Application no: H16/1151/97

Description: Erection of garage

Location: Dolphin House, Horseshoe Road
Spalding
Lincs

Amendment: Minor re-siting to avoid tree stumps
Drawing No. 97/011/PA/004

PROPOSED RESITING PLAN

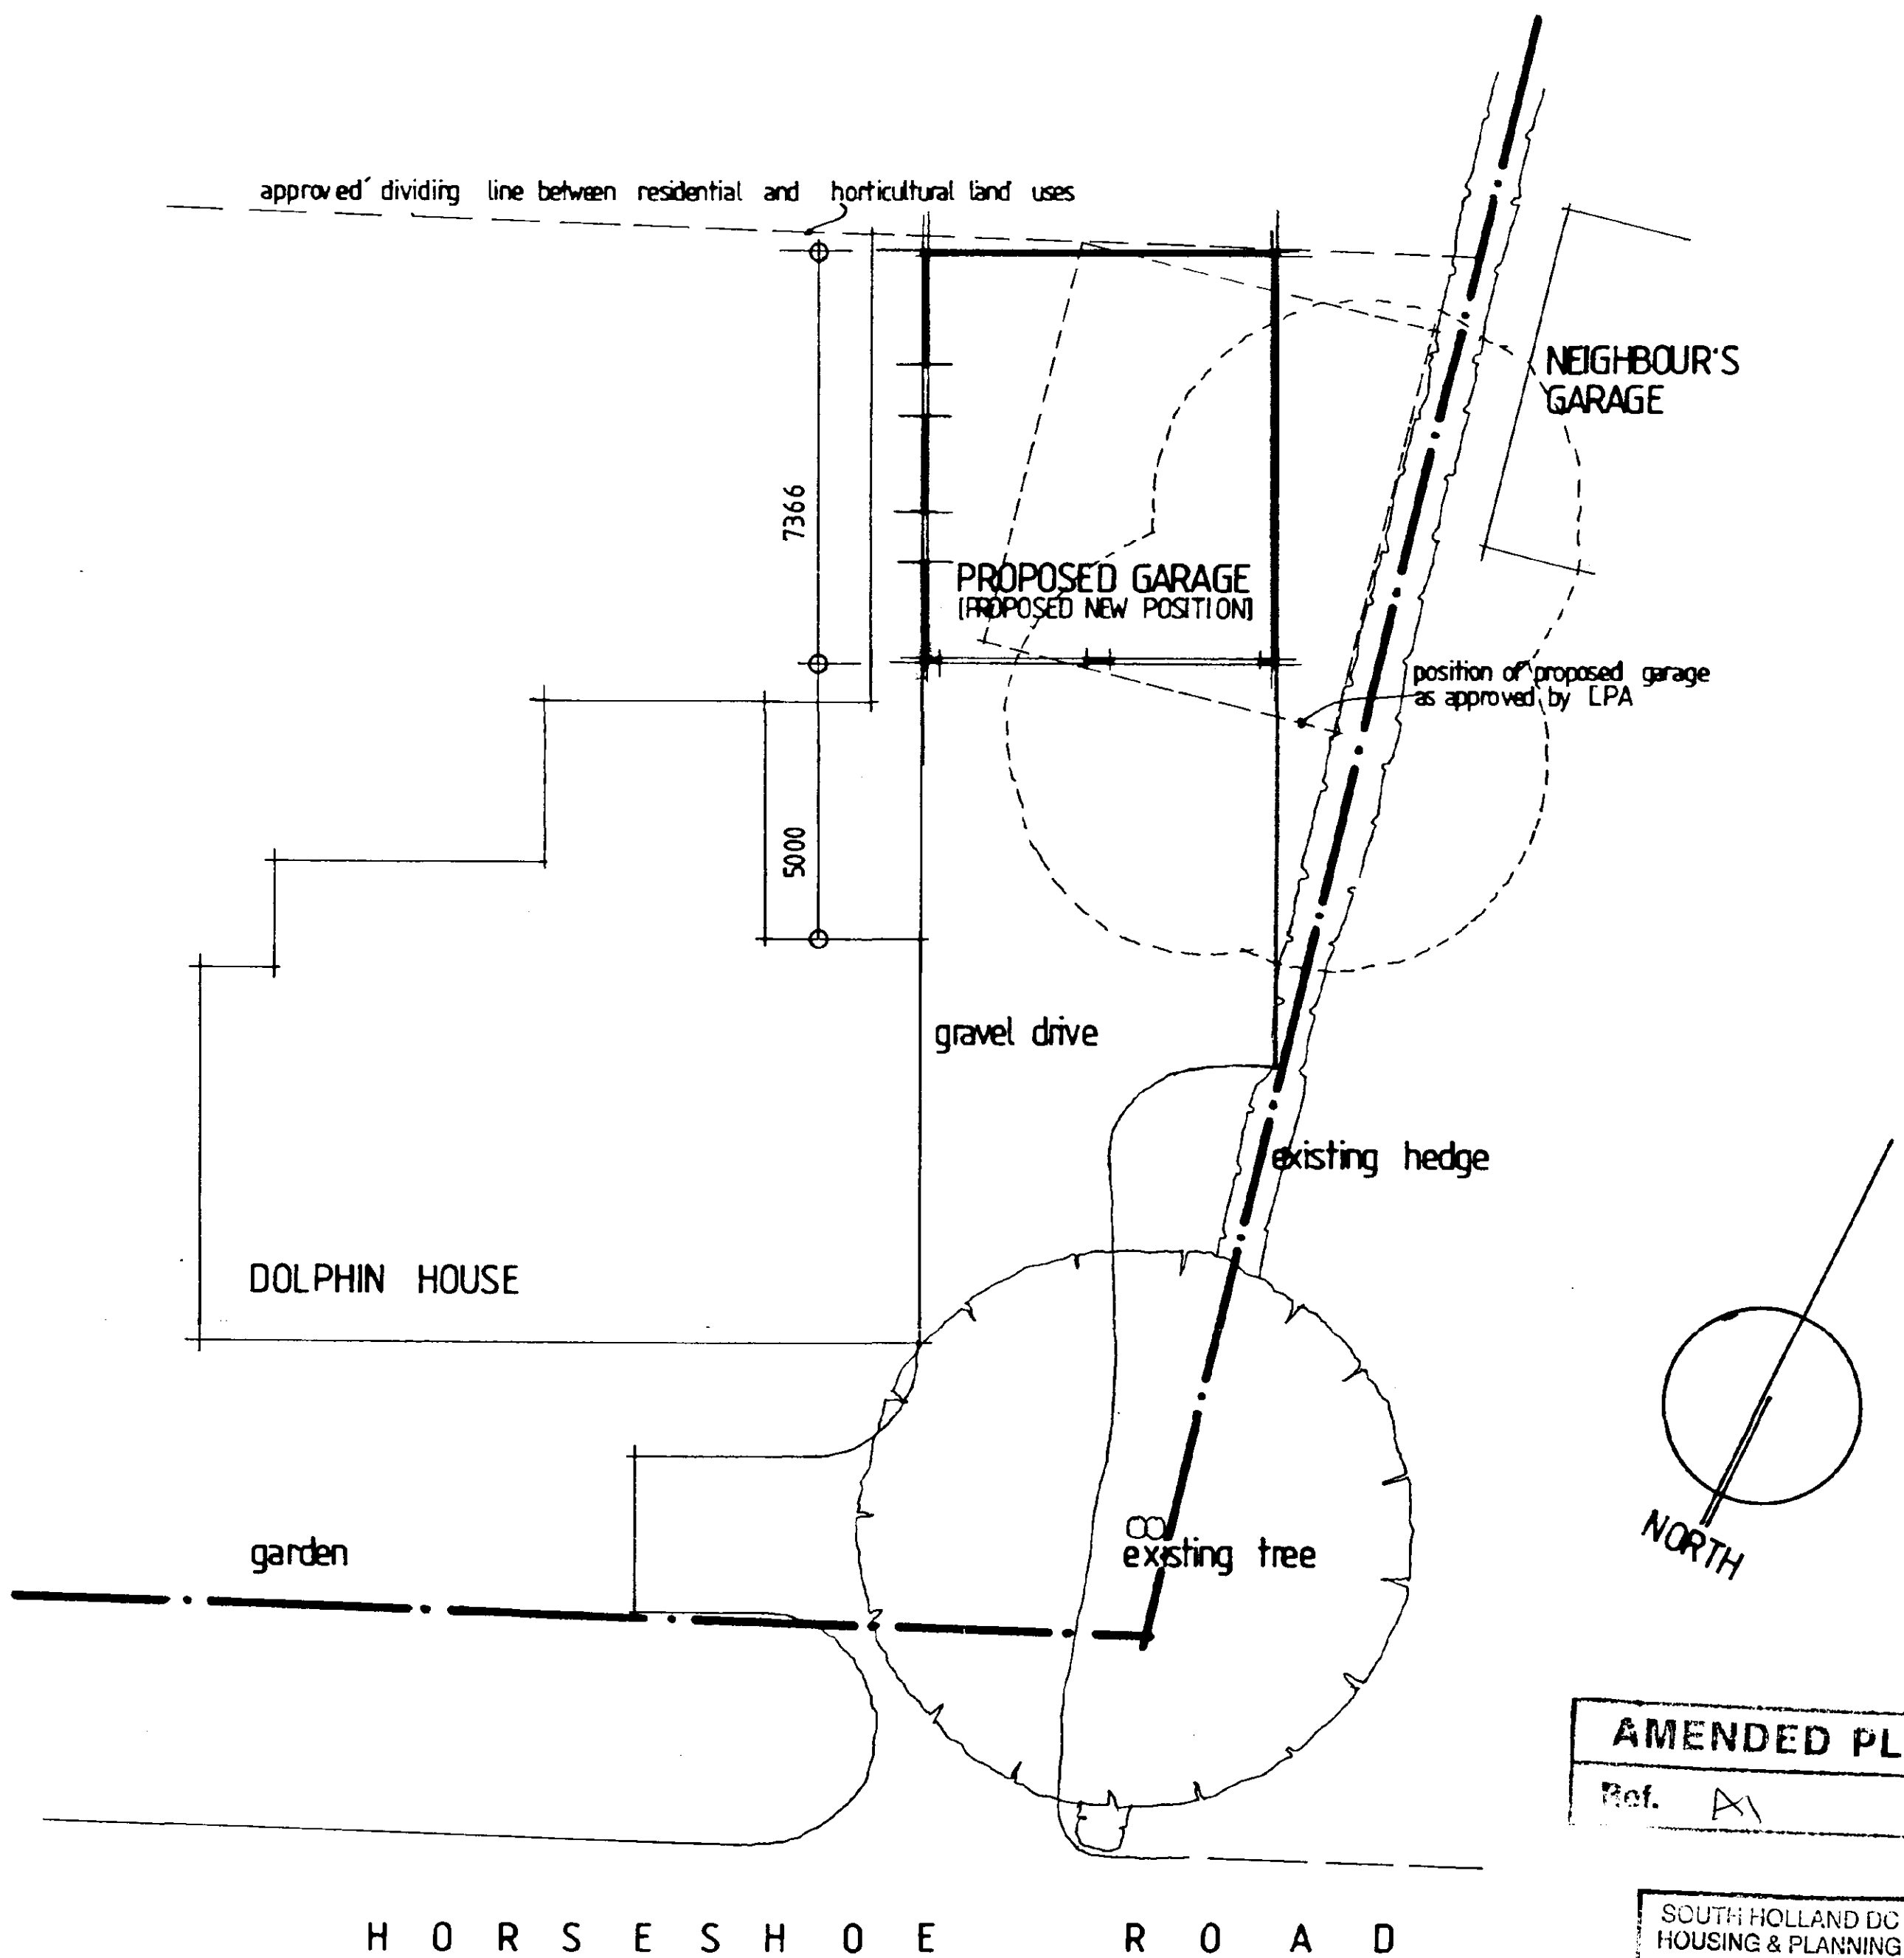
MINOR RESITING TO AVOID
TREE STUMPS
THIS HAS NO EFFECT UPON THE
SURROUNDINGS AND THE
NEIGHBOUR HAS NO OBJECTION

The amended details submitted in respect of the above proposal have now been considered, and I am able to inform you that there are no objections to the amendment being implemented to the extent described above.
